Consultation Response from KC, Lead Local Flood Authority
2023/93236 Pentlands, New Mill Road, Holmfirth, HD9 7LN
Discharge conditions 4 (Internal Estate Road Details), 5 (Parking Bay Surfacing & Drainage), 9 (Temporary Waste Measures), 11 (Surface Water Drainage Details), 12 (Overflow Event Scenario), 13 (Separate Forms of Drainage Details), 15 (Temporary Drainage Measures), 22 (Ecological Enhancement Plan) on previous permission 2020/91896 for demolition of existing dwelling and erection of 15 dwellings with associated access and external works
Date Responded: 12th March 2024 Responding Officer: Paul Farndale Responding Ref:

Condition 11 – Drainage Details

W-2478-23-Pentlands, New Mill Road, Holmfirth

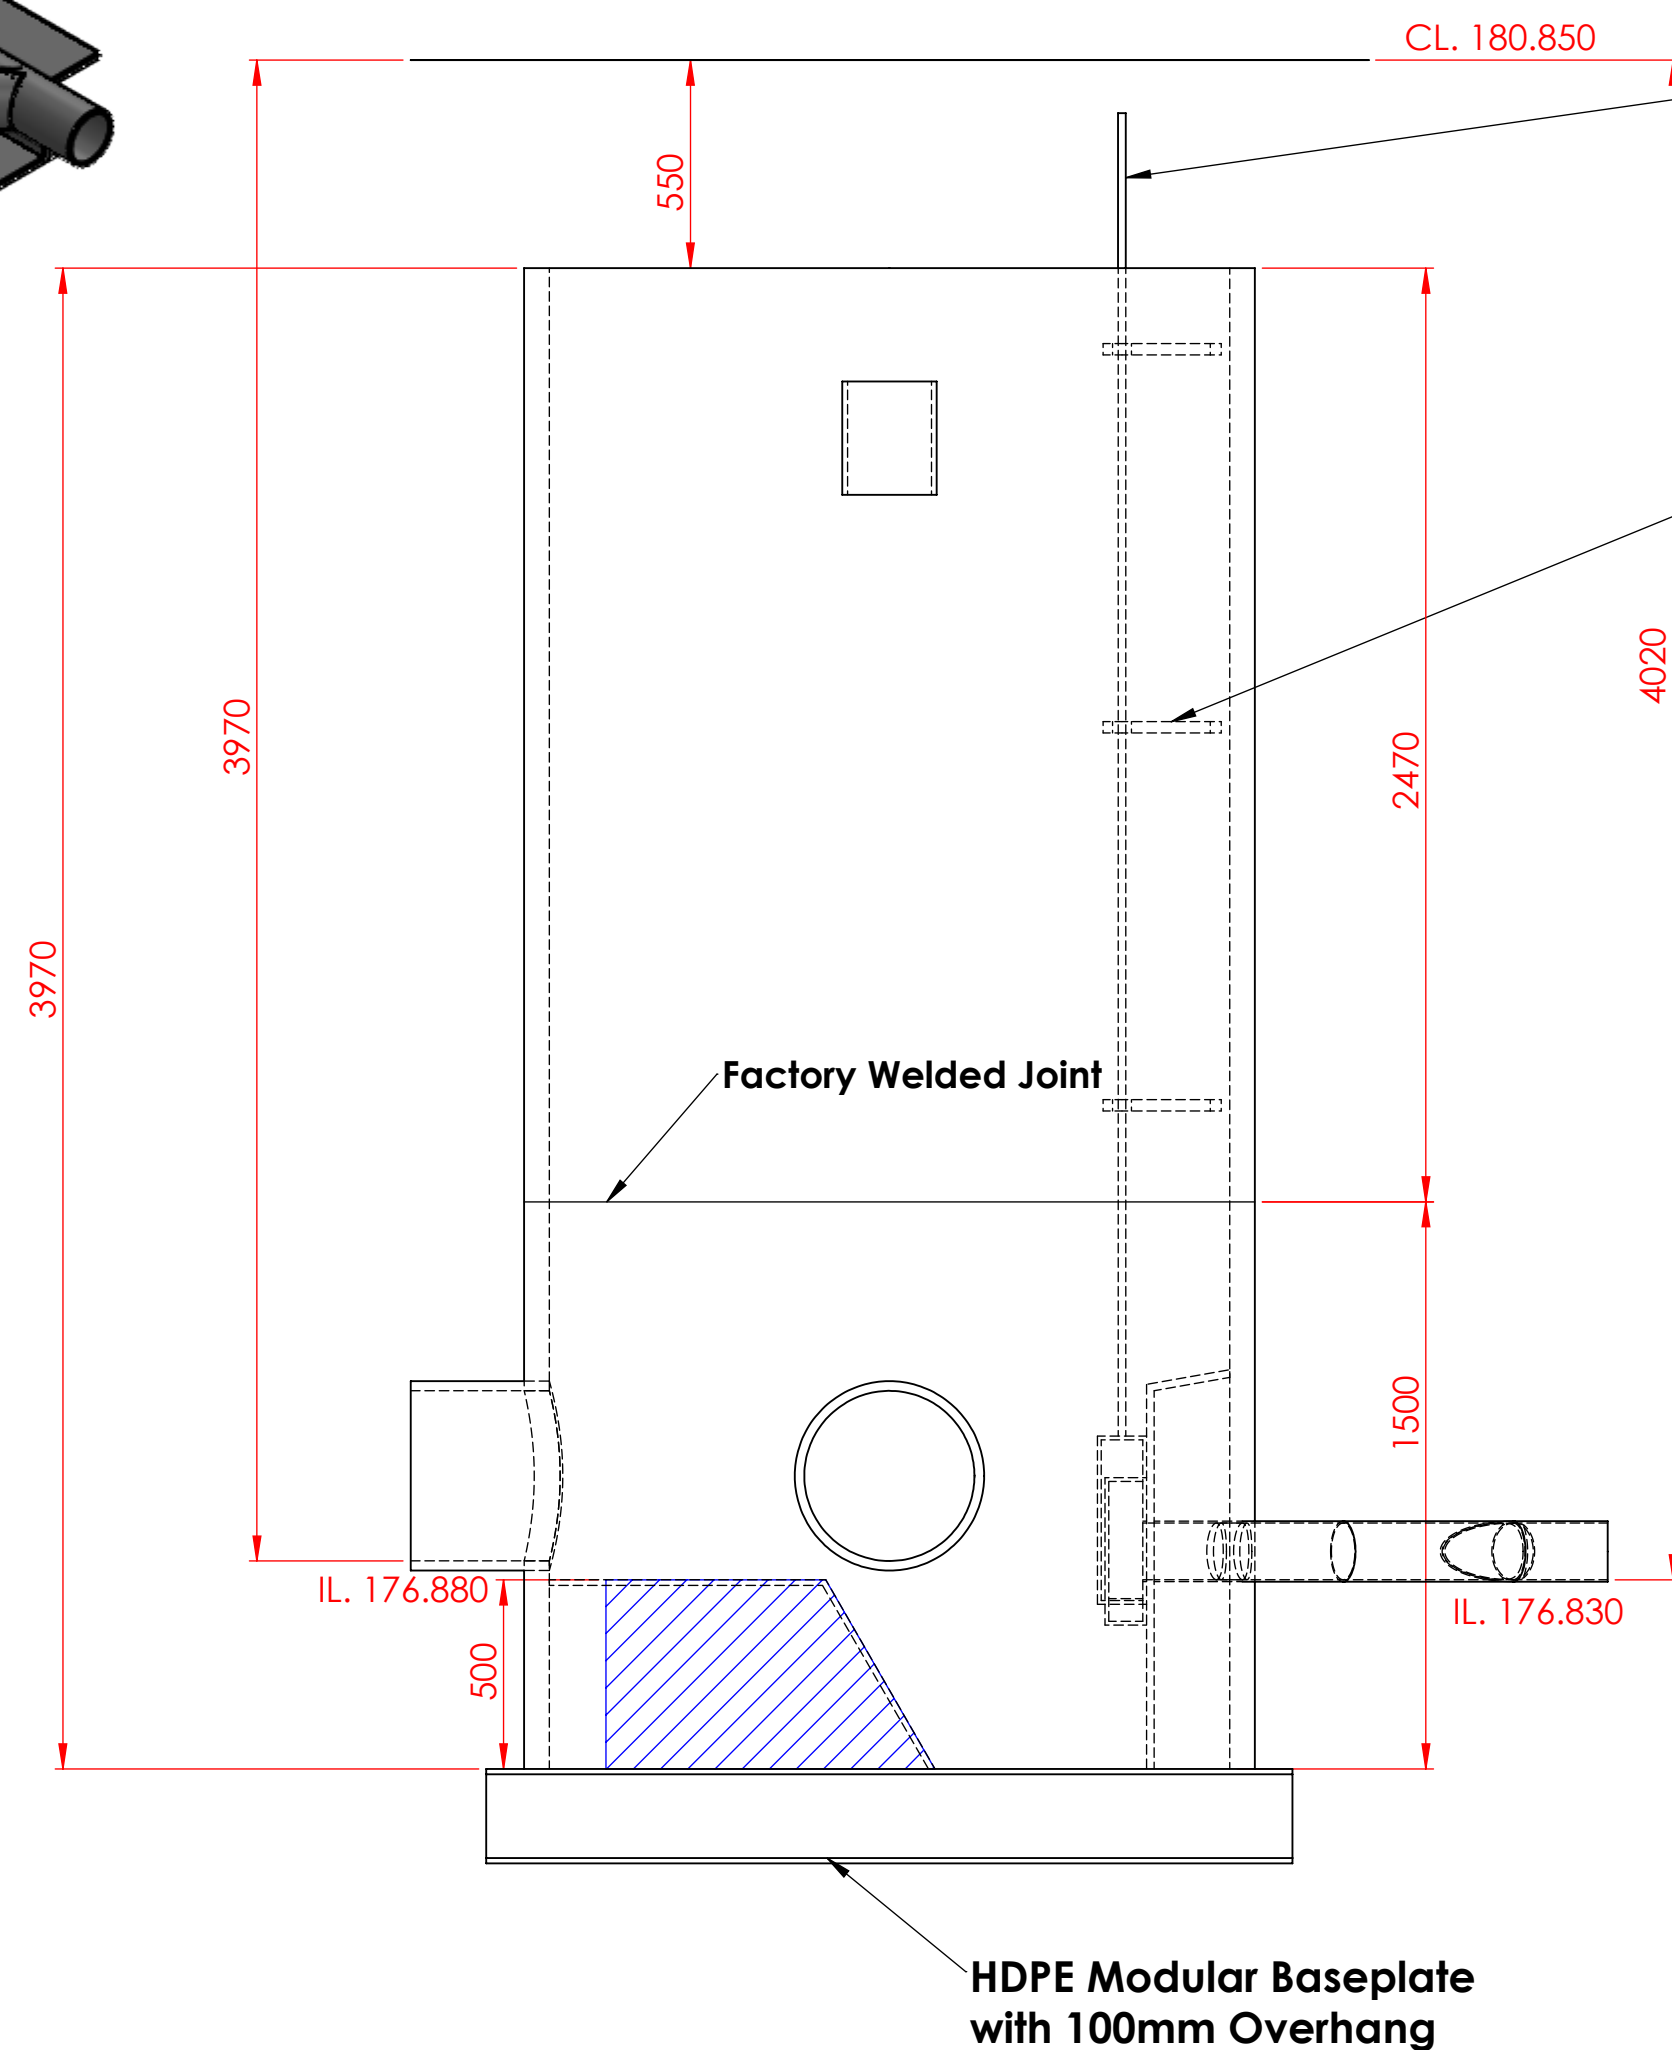
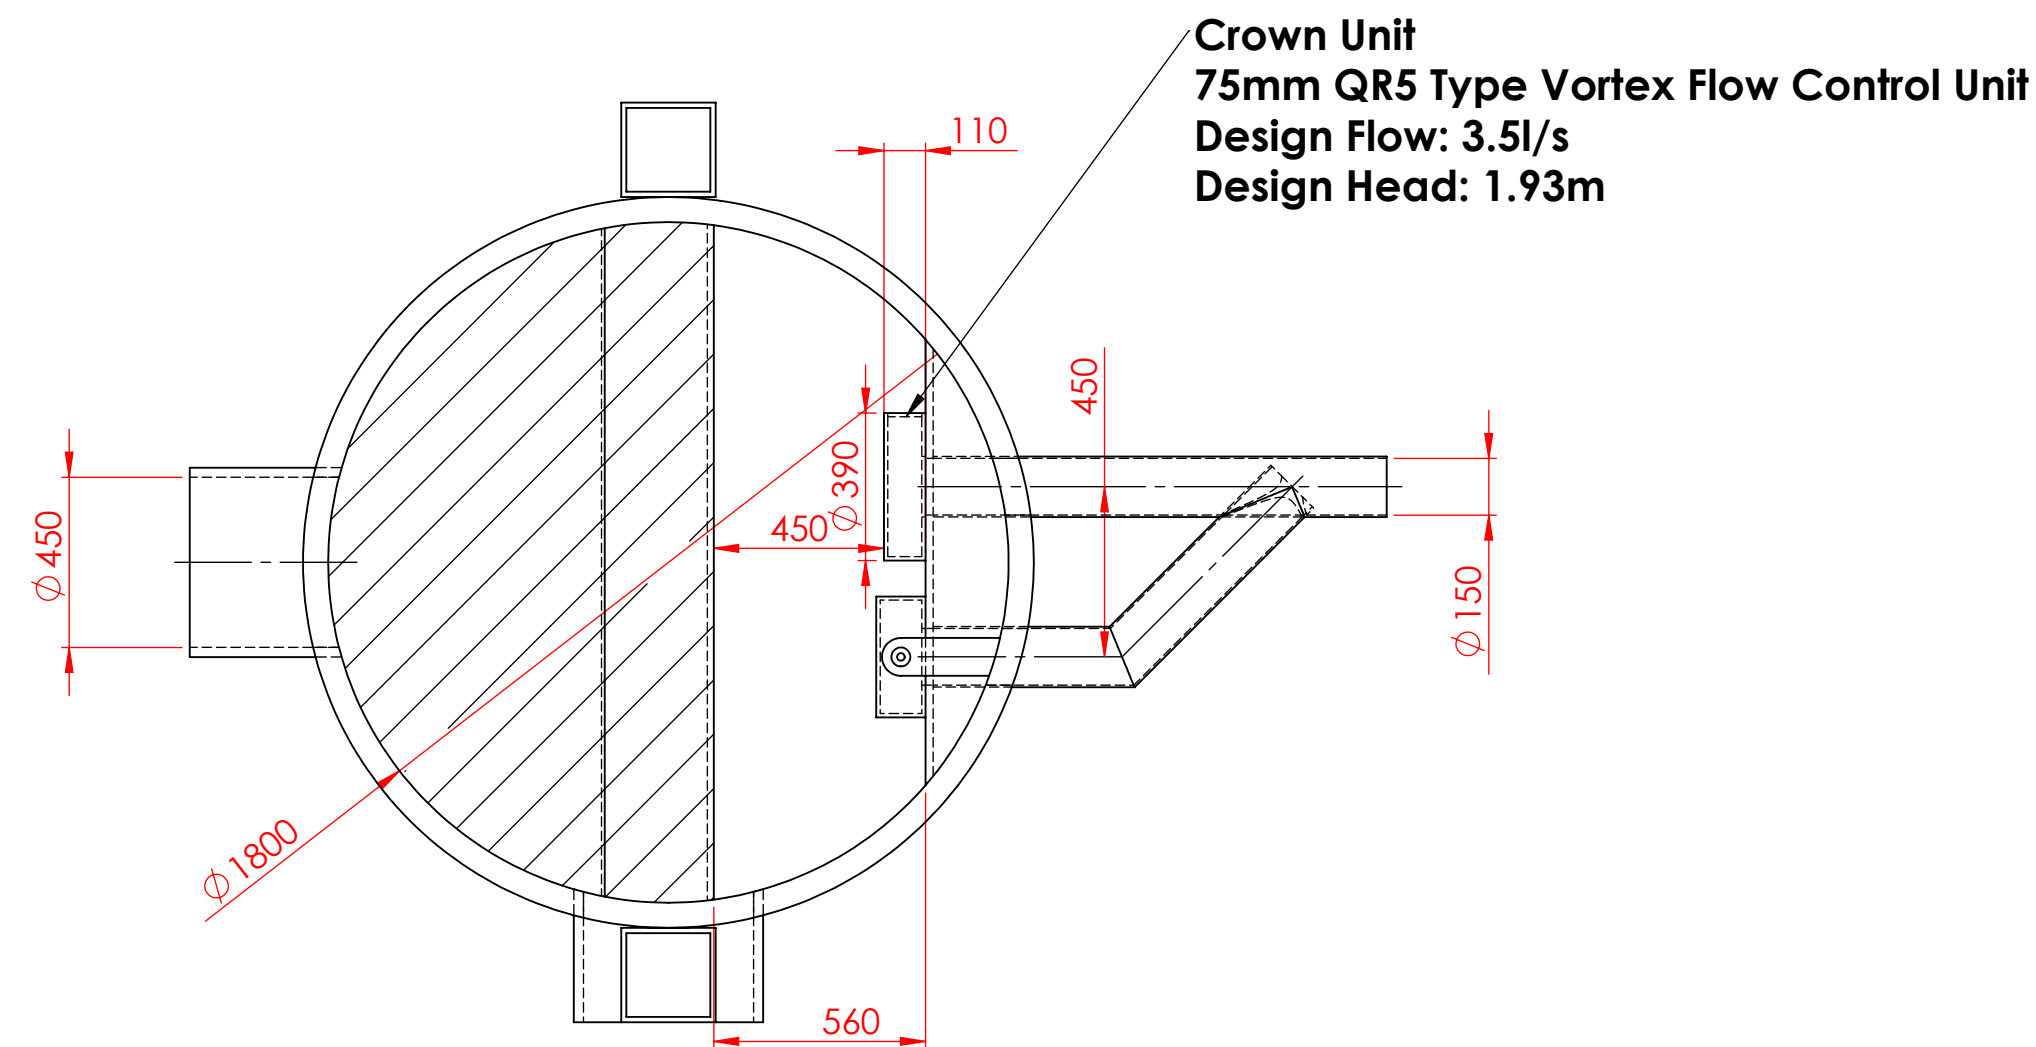
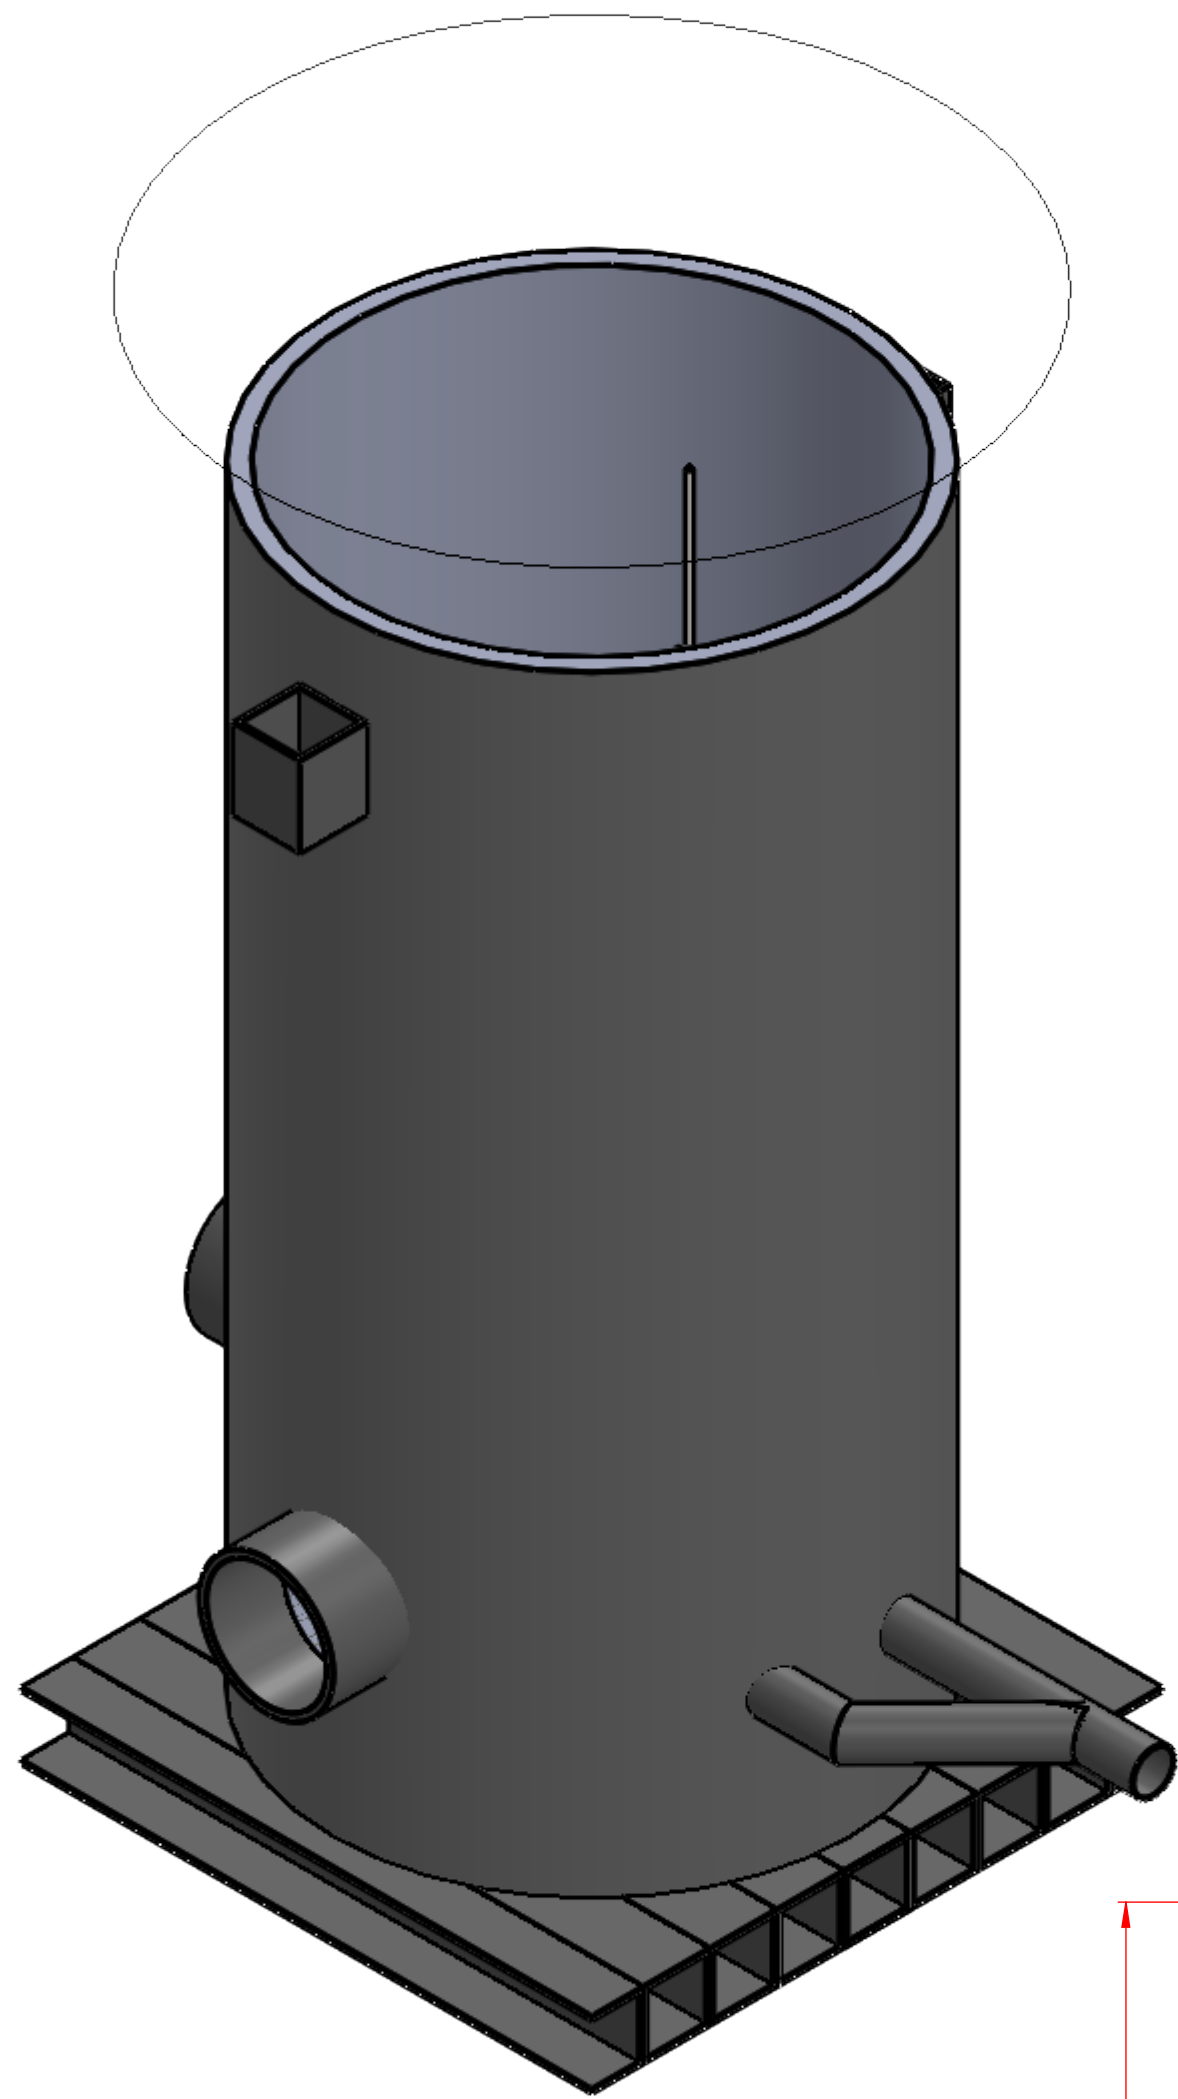
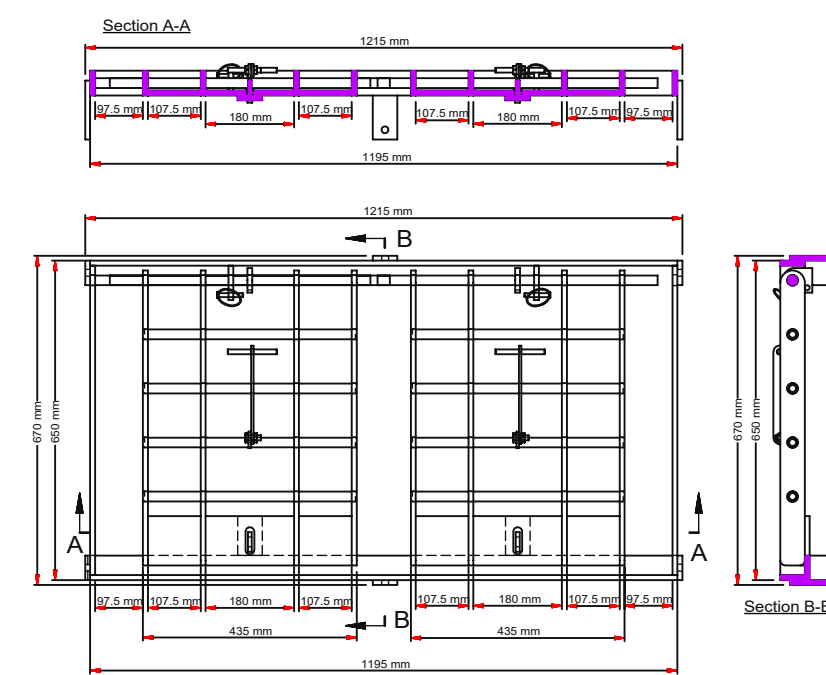
Details of the tank design including invert and cover levels has been provided. However, this is contrary to what was discussed for planning application 2020/91896 which allowed approval subject to condition. At this point the application went forward with pre-cast concrete tank having been agreed. This principle has been reneged upon

As an additional note, the calculations provided are for a different sized tank than submitted on the plan. No allowance for void ratio has been included.
